Our ref: HA/2018/120877/01-L01
Your ref: BR/214/18/PL
Date: 27 November 2018

ERECTION OF FOUR TERRACED RESIDENTIAL DWELLINGS, GARDEN/CYCLE STORAGE SHEDS & ASSOCIATED CAR PARKING, UTILISING THE EXISTING ACCESS

FORMER HOTEL TENNIS COURTS ADJ TO THE ROYAL NORFOLK HOTEL, WEST STREET, BOGNOR REGIS, PO21 2LH

Drg No: **RNHB.PLAN 1**

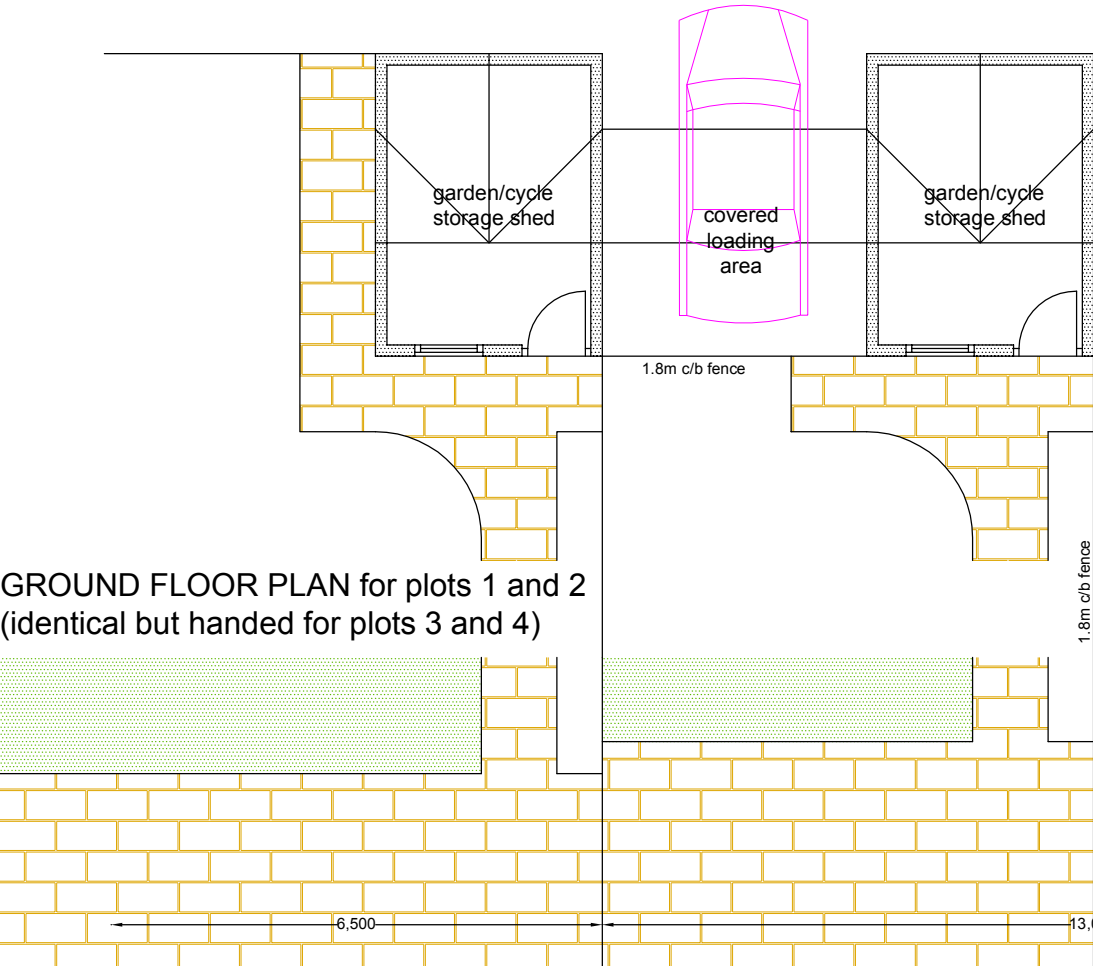
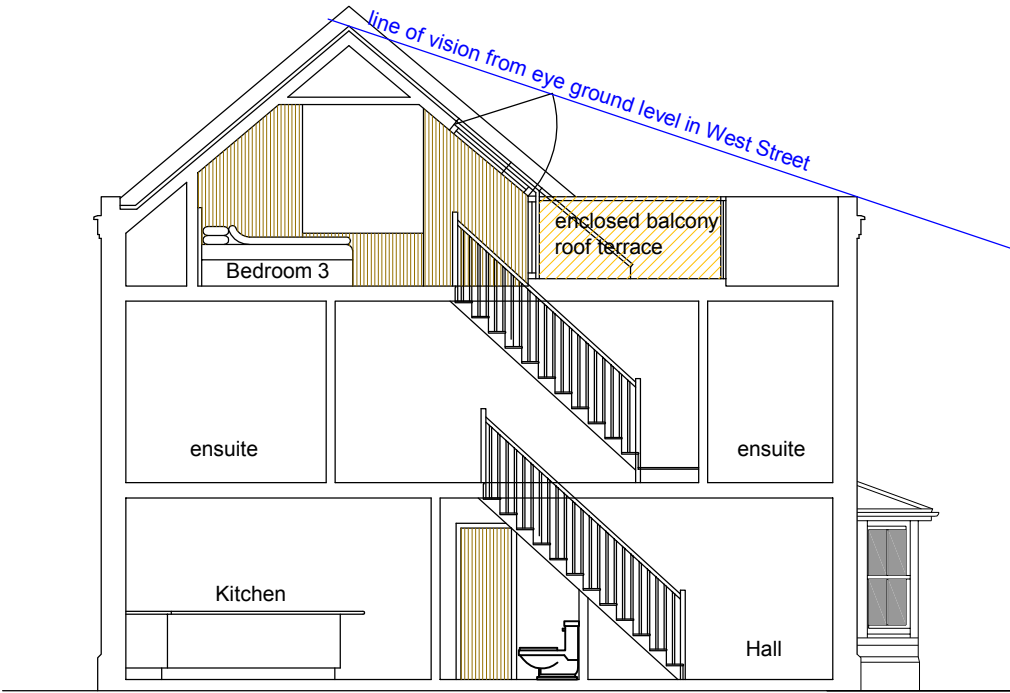
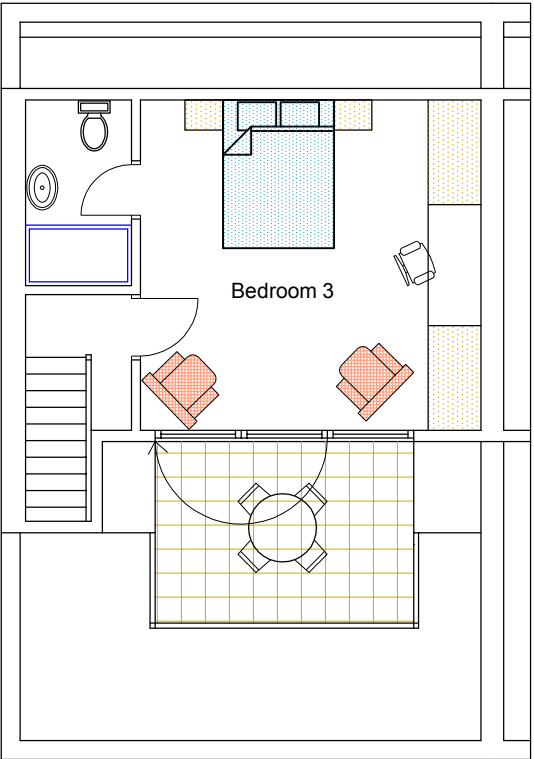
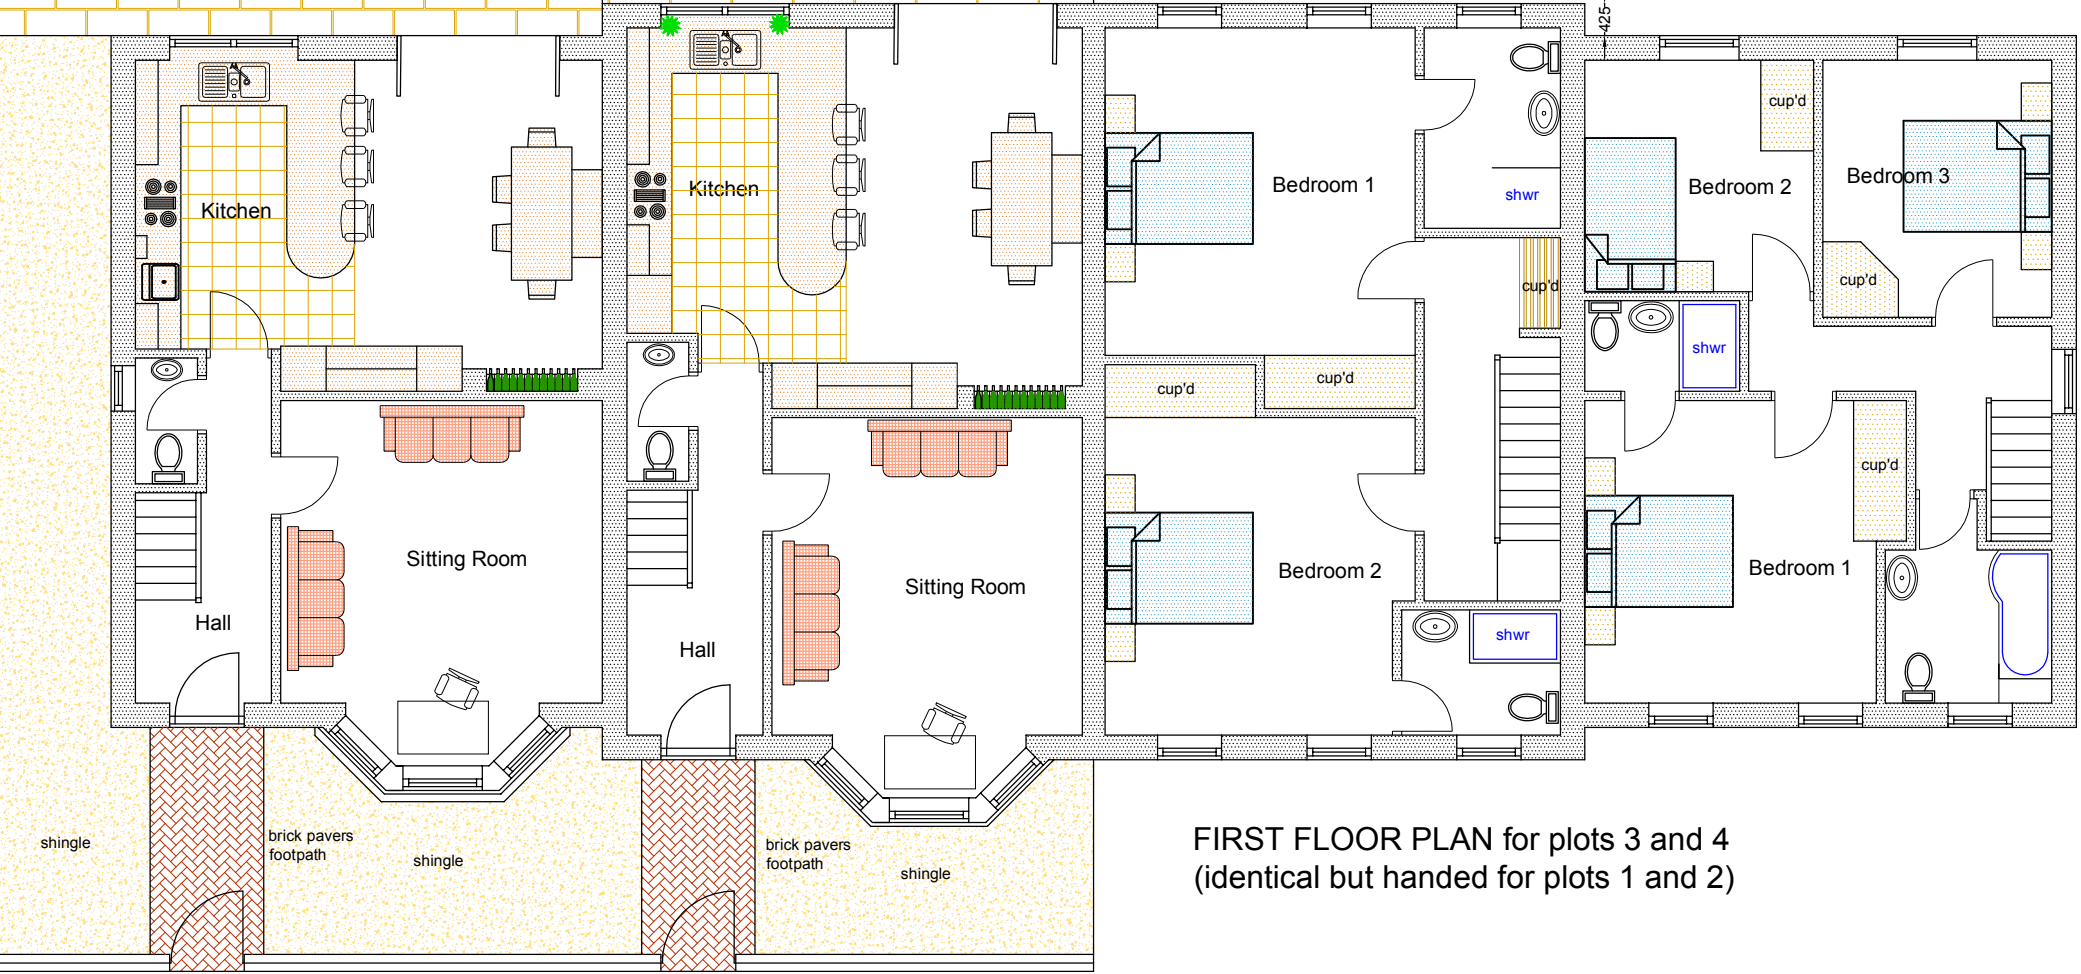
The development permitted by this planning permission shall only be carried out in accordance with the approved Flood Risk Assessment (FRA) (November 2018) and the following mitigation measures detailed within the FRA:

- **Finished floor levels are set no lower than 5.72 metres above Ordnance Datum (AOD).**
